**KIRKLEES METROPOLITAN COUNCIL
INVESTMENT & REGENERATION SERVICE**

DELEGATED DECISION TO DETERMINE PLANNING APPLICATIONS

Reference No:	2024/62/91678/W
Site Address:	3, Stainecross Avenue, Crosland Moor, Huddersfield, HD4 5HZ
Description:	Erection of detached garage (retrospective)
Recommending Officer:	Joanna Rednall

DECISION - REFUSED

TITLE
PROPOSED & EXISTING FLOOR PLANS AND ELEVATIONS

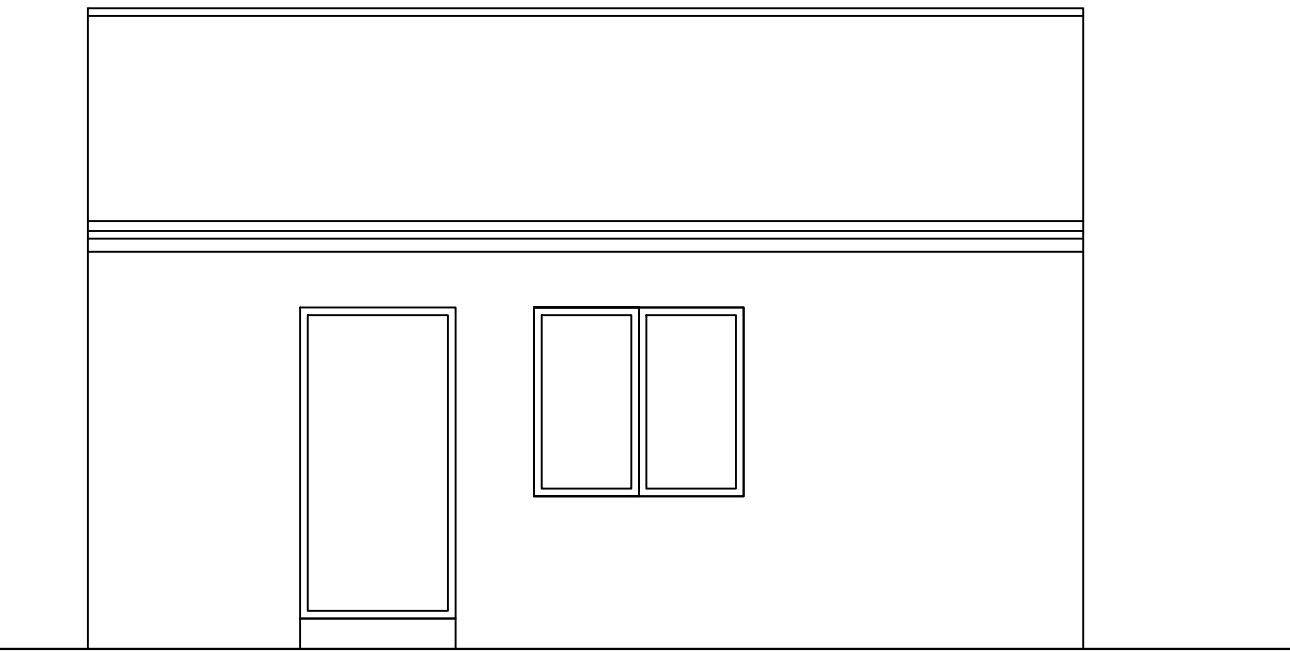
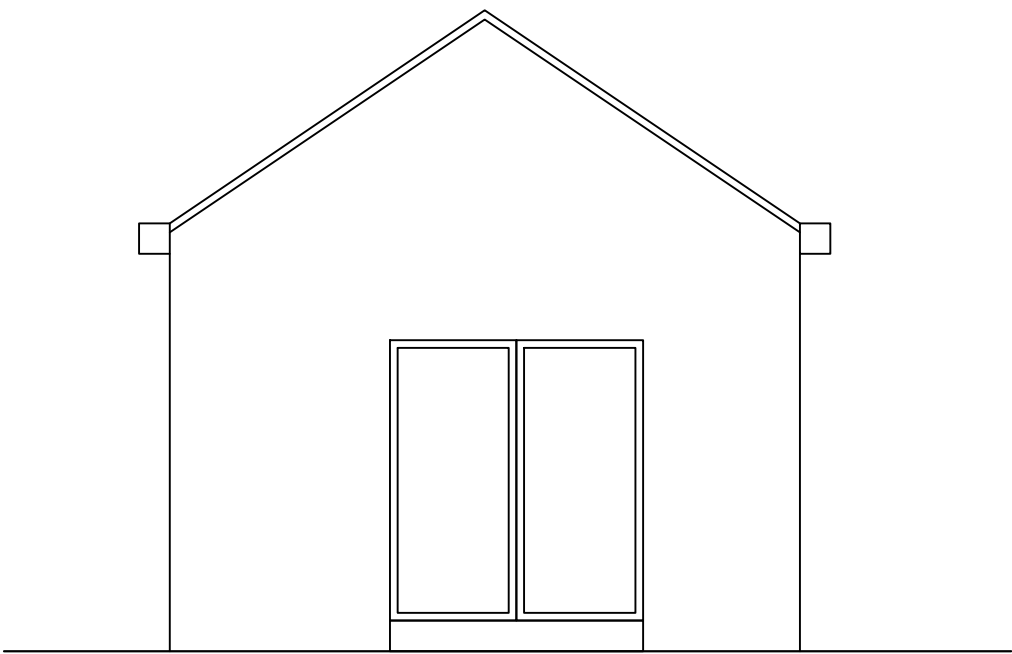
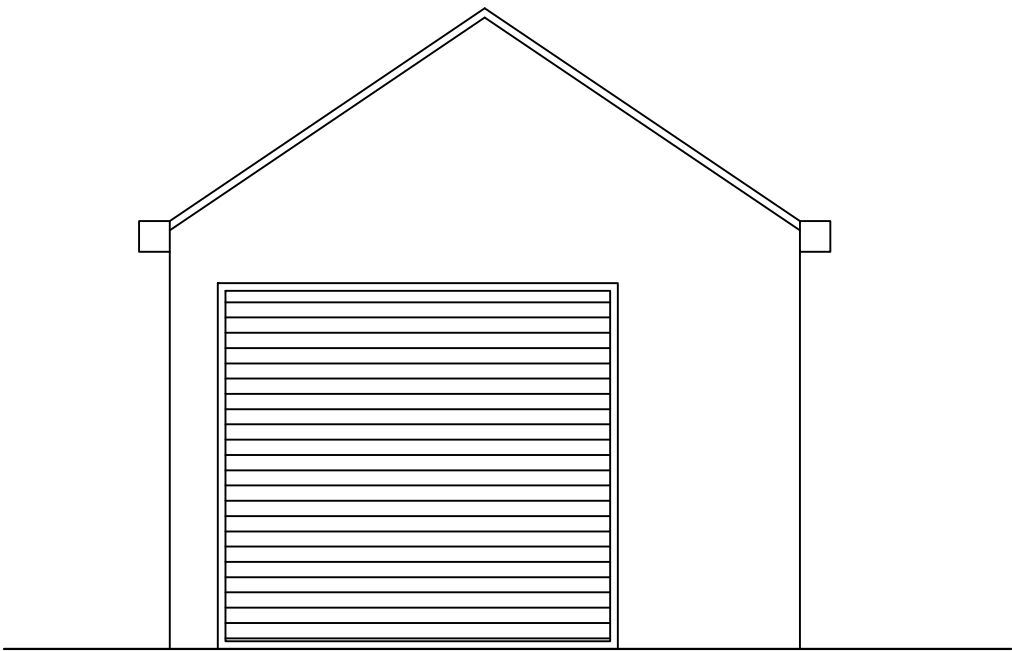
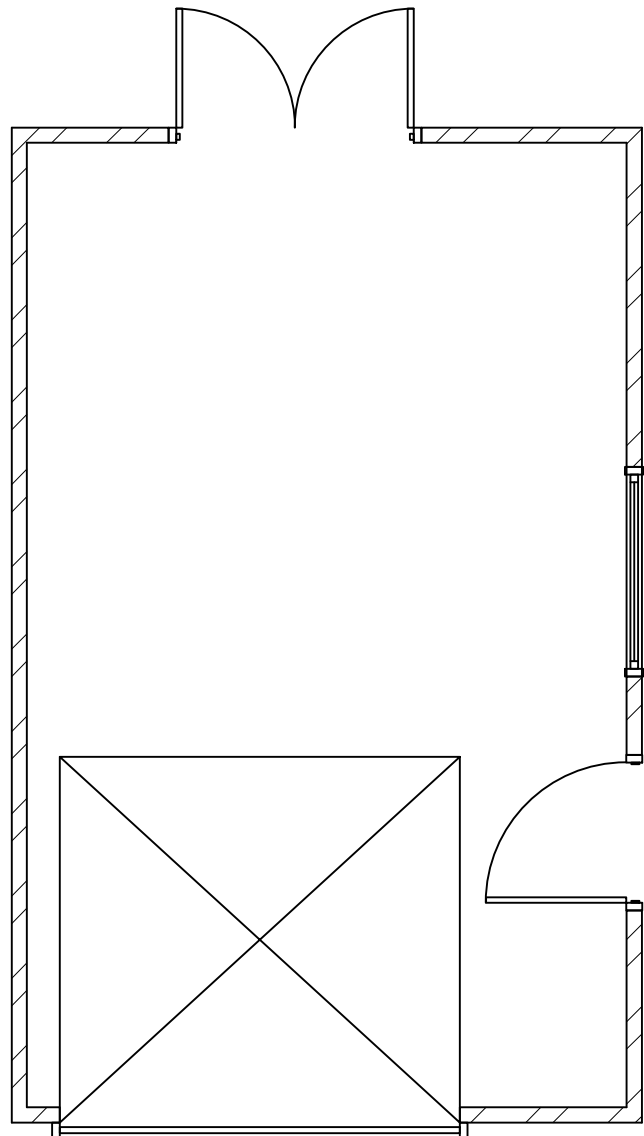
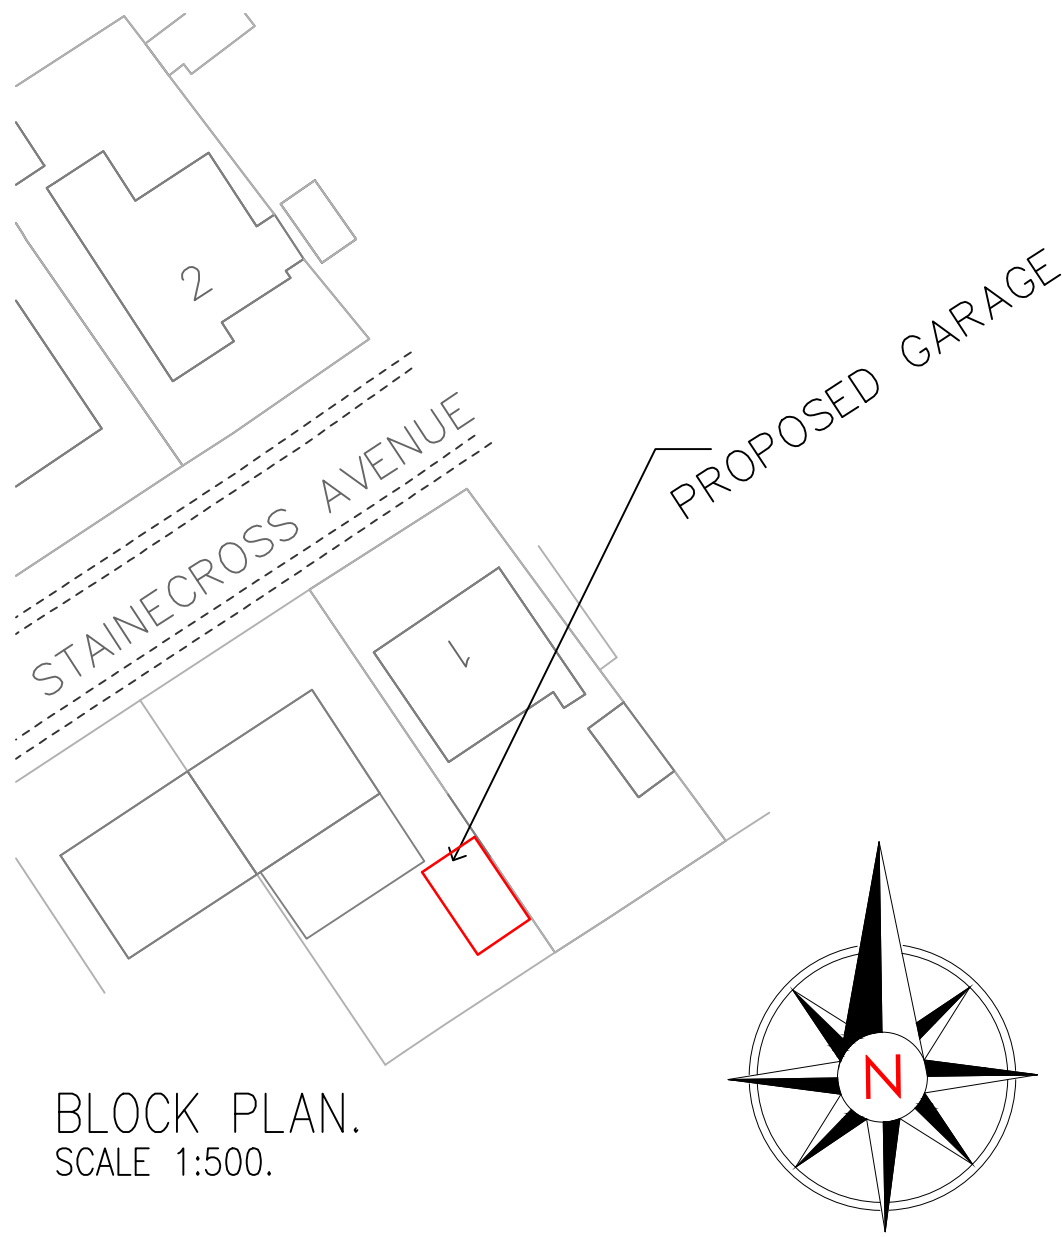
The detached garage is located within the rear curtilage of the dwellinghouse with a width of approx. 4.1m, a depth of approx. 6.5m and a maximum height of approx. 4.2m. The garage has been constructed from stone and concrete block along the shared boundary wall with No.1, Stainecross Avenue, with a gable roof incorporated above. A previous garage, of smaller dimensions sited to the rear of No.3 has been approved under application 2019/93655.

Whilst the structure would accord with the SPD to a certain extent, it is noted that the outbuilding would be sited on significantly higher ground level than neighbouring properties to the north-east, in a prominent location adjacent to this boundary. Due to its siting and scale, the outbuilding is highly visible from public vantage points along Stainecross Avenue and would be a prominent feature within the locality.

Concerns have been raised with regard to materials. Following a site visit and from the information submitted, it appears the garage has been constructed from stone to the front, side (south-west facing) and rear elevations and poor-quality concrete blocks to the north-east facing elevation with a gable roof above infilled with tiles. Given the difference in ground levels whereby No.1 is sited at a lower ground level to No.3, the detached garage would not appear subservient due to the substantial bulk and massing along the shared boundary that is visible from the wider street scene on 3, Stainecross Avenue, which is exacerbated by the materials utilised on the side elevation.

The detached garage is located along the boundary, extending approx. 6.5m in depth at a total height of approx. 4.2m. It is considered the design, scale and siting of the garage would be detrimental to the residential amenity of this neighbour.

In regard to overbearing, it has been assessed that the development would intensify development to the north-east of the application site and create significant bulk and massing along the shared boundary. As previously noted, this neighbour is located at a lower ground level to the application site, and the garage is constructed along the shared boundary. Given these factors, the significant massing proposed under this application creates an unacceptable overbearing impact upon the rear amenity space of No.1 and creates an unacceptable oppressive impact. In addition, the gable roof design provides an additional approx. 1.2m in height along the shared boundary, creating an unacceptable oppressive impact. This is considered to unduly reduce the outlook of occupiers at No1, Stainecross Avenue, and is therefore unacceptable with regard to residential amenity.

With regards to overlooking/ privacy, the proposed plans show two openings inserted to the side/ southwest facing elevation in the form of a door and a window. The garage is situated at the opposite side of the dwellinghouse and away from these neighbours and is not a habitable building. As such there will be no further impact on these neighbours' amenity in regard to overbearing, overshadowing and overlooking.

This neighbour is located south-west/ rear of the application site. The submitted plans show openings in the form of patio doors to the rear elevation, and the garage set approx. 2.6m away from the shared boundary.

With regard to overlooking, it has been assessed that there would be some harm as new patio doors will be inserted into the rear elevation of the garage. The garage is not a habitable room and is set away from the shared boundary, therefore on balance any impact would not be significant enough to warrant refusal in this regard. Boundary treatment is in place in the form of fencing that would alleviate the detrimental harm to overlooking.

1. The detached garage, by reason of its scale, siting and materials would create an incongruous feature that would form an inappropriate feature with the host property and street scene and would be harmful to the

character of the area. To permit the detached garage would be contrary to policy LP24 of the Kirklees Local Plan, KDP 1 & KDP 2 of the House Extensions and Alterations SPD and Chapter 12 of the National Planning Policy Framework.

1. As a result of the siting and proximity of the development to 1, Stainecross Avenue, the detached garage, by reason of its size, scale and siting, results in a detrimental overbearing and oppressive impact upon the occupiers of 1, Stainecross Avenue. To permit the detached garage would be contrary to policy LP24 of the Kirklees Local Plan, KDP 5 & KDP 6 of the House Extension SPD and chapter 12 of the National Planning Policy Framework.
